Please ask for: Mrs D Johnson
Email: daun.johnson@arun.gov.uk
Telephone: 01903 737762
Our Ref: BR/85/20/PL
Your Ref:
Date: 6th April 2020

Application for Planning Permission

Development: Replacement of the Football Clubs grandstand.
Location: Bognor Regis Football Club Nyewood Lane Bognor Regis PO21 2TY

Block Plan shows area bounded by: 492394.92, 99345.41 492484.92, 99435.41 (at a scale of 1:500), OSGridRef: SZ92439939. The representation of a road, track or path is no evidence of a right of way. The representation of features as lines is no evidence of a property boundary.

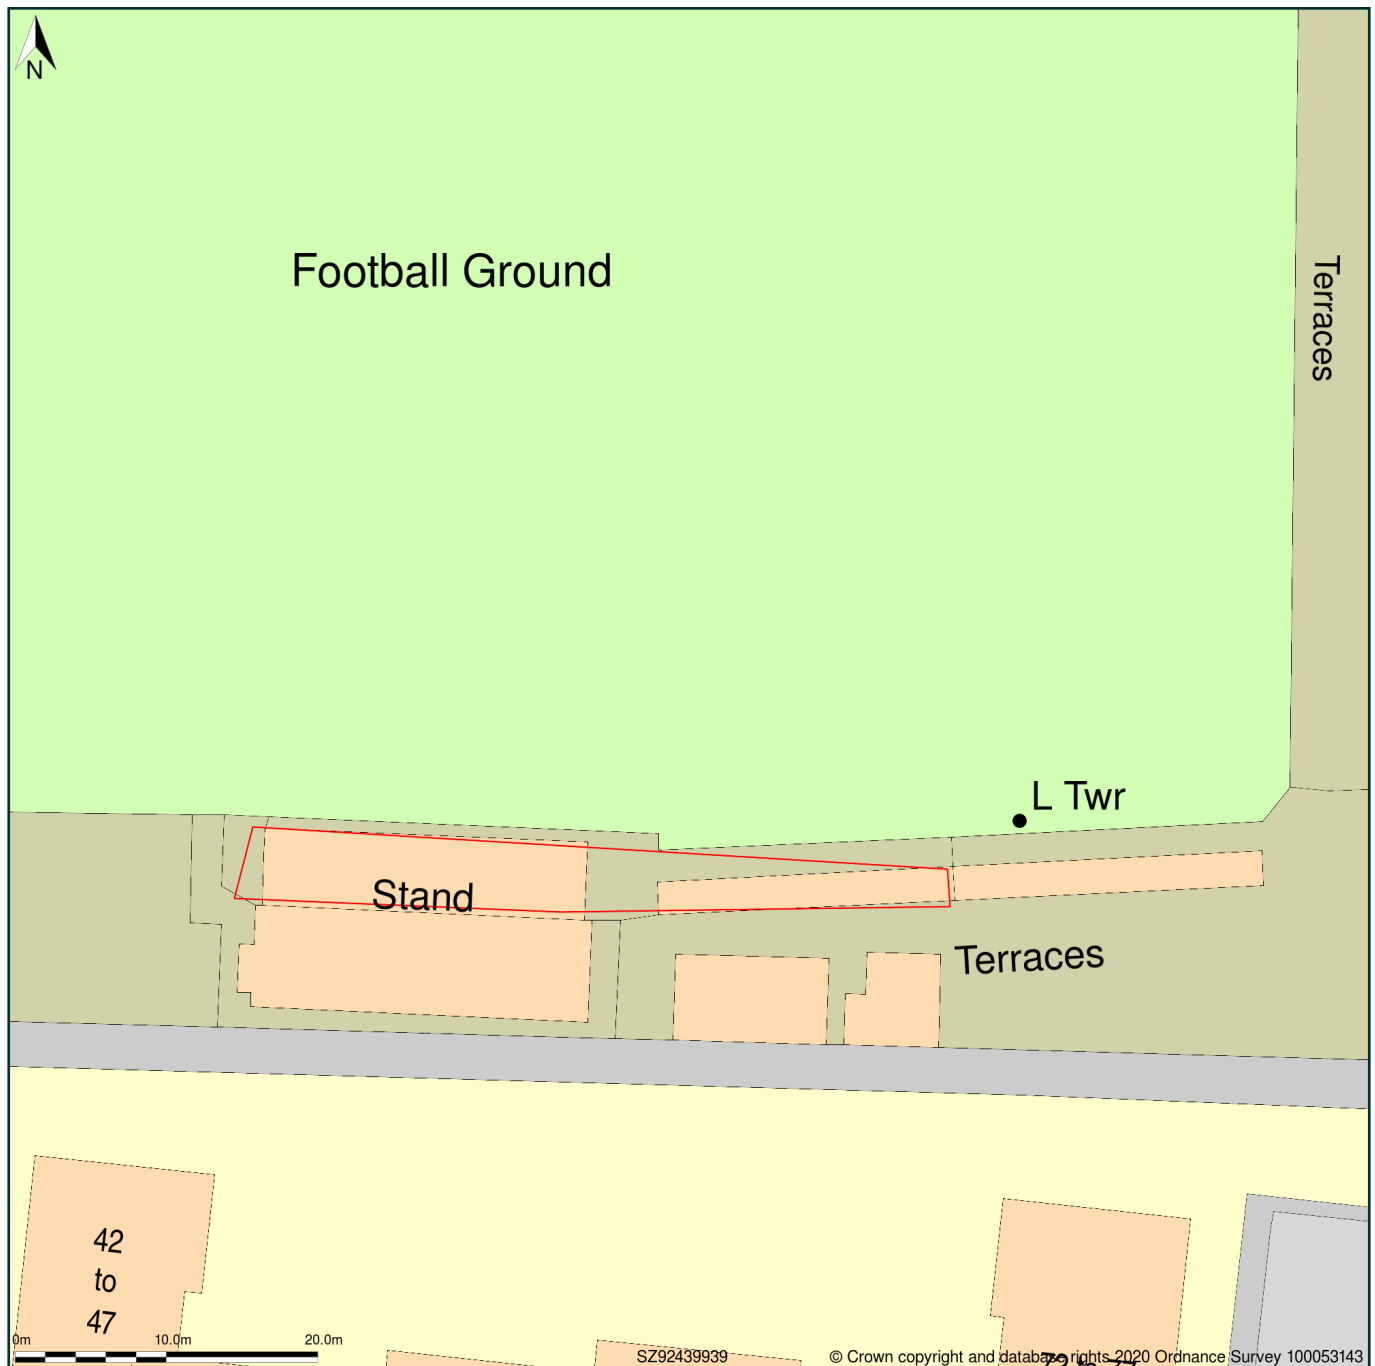
Please ensure the location plan is correctly red edged. The red edge does not appear to be accurate.
